From: Sarah Burrow <Sarah.Burrow@arun.gov.uk>
Sent: 05 June 2020 11:26
To: Planning.Responses <Planning.Responses@arun.gov.uk>
Cc: Amber Willard <Amber.Willard@arun.gov.uk>
Subject: RE: Planning Consultation on Y/44/20/DOC

Engineers Comments Regarding Surface Water Drainage

APPLICATION NO: Y/44/20/DOC

Site Address: The Maypole Inn Maypole Lane Yapton BN18 0DP

Typical Silt Trap Inspection Chamber Detail
(for use in areas not subject to vehicle loading)

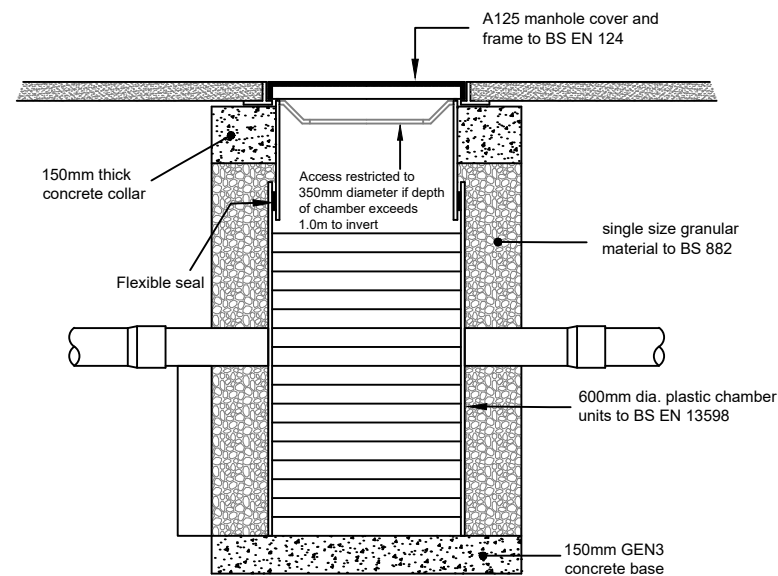
1. The silt trap construction detail drawing states that it should not be subjected to vehicular loading, however the silt trap is shown within the parking area on the drainage layout. Please move into a landscaped area or specify a silt trap which can tolerate vehicular loading.
2. Please confirm trial pits were sized in accordance with BRE365 (min 0.3m x 1m)
3. Please include sump level for the catch pit.
